<b>Application Ref:</b>	3/2025/0559	 Ribble Valley Borough Council <a href="http://www.ribblevalley.gov.uk">www.ribblevalley.gov.uk</a>
<b>Date Inspected:</b>	17/10/22	
<b>Officer:</b>	BT	
<b>DELEGATED ITEM FILE REPORT:</b>		<b>NON MATERIAL AMENDMENT</b>

<b>Application Description:</b>	Non material amendment to application 3/2022/0791 involving amendments to the proposed elevations.
<b>Site Address/Location:</b>	Twitter Bridge Farm, Twitter Lane, Waddington, BB7 3LG.

Rear Elevation (South-East)

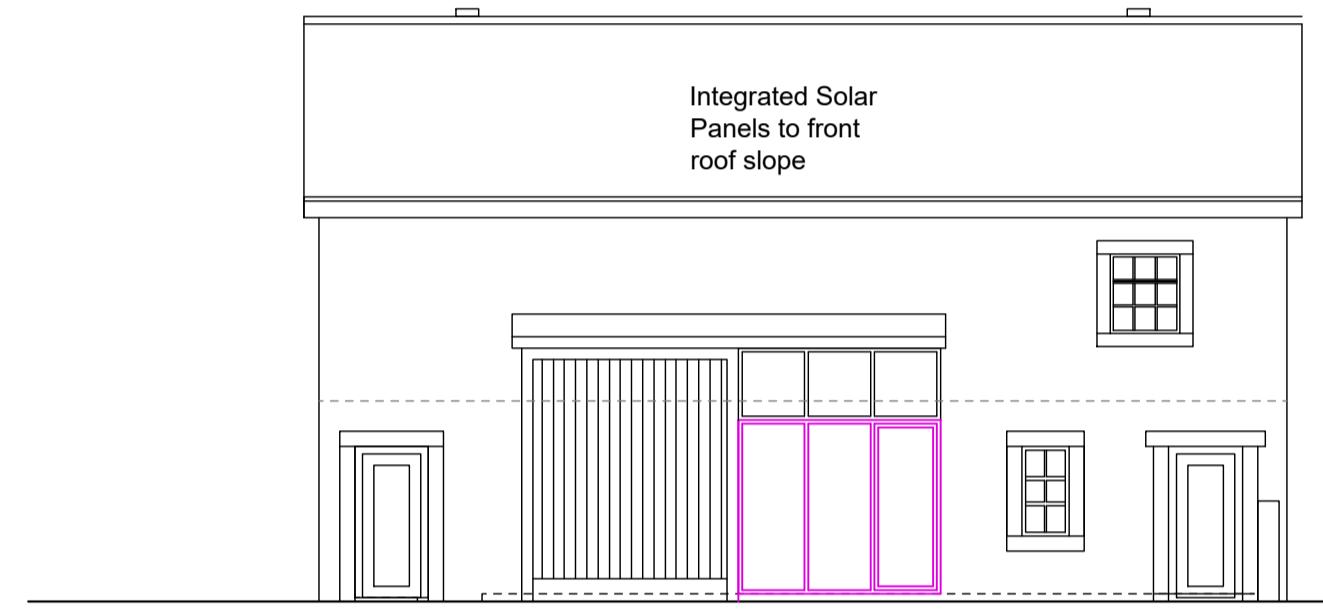
<b>ASSESSMENT OF PROPOSED DEVELOPMENT:</b>
<b>Nature of Non-Material Amendment:</b>
<p>Consent is sought for a non-material amendment to application 3/2022/0791 which granted consent for the conversion of a barn building to a dwelling (previously approved under planning application 3/2018/0750).</p> <p>The purpose of the application is to seek the Council's opinion as to whether the changes to the previously approved development are sufficiently material in their nature and in the context of the approved development so as to require a new planning permission. Non-material amendment applications are not an application for planning permission. They do not result in the issuing of a new planning permission and relate only to the amendments sought.</p> <p>In this instance, the amendment sought relates to changes to the internal layout, fenestration and roof detailing approved under application 3/2022/0791. The application's supporting information states that the proposed changes are required in order to provide more natural light into the rooms of the converted barn. The amendment sought comprises numerous changes to the originally approved development. These changes include alterations to the alignment of approved ground and first floor window openings within the South-western gable end of the barn building and the substitution of a glazed opening, single door opening and cladding on the South-western profile of the barn's outshut component with full height glazing. Four new window openings are also proposed for the North-eastern gable end of the barn building which did not form part of the originally approved development. Further changes proposed include the introduction of integrated solar panels to the principal South-eastern roof slope of the barn building which</p>

would be noticeably at odds with the historic slate roof profile of the traditional barn building and these would also be fully visible in the public realm from Twitter Lane. Further alterations are also proposed to the approved configuration of rooflight openings on the rear North-western roof slope of the barn building, with five originally approved rooflight openings being replaced with three rooflight openings that would be aligned in a distinctly linear and regimented fashion in noticeable contrast to the randomised sequence of the originally approved rooflight openings.
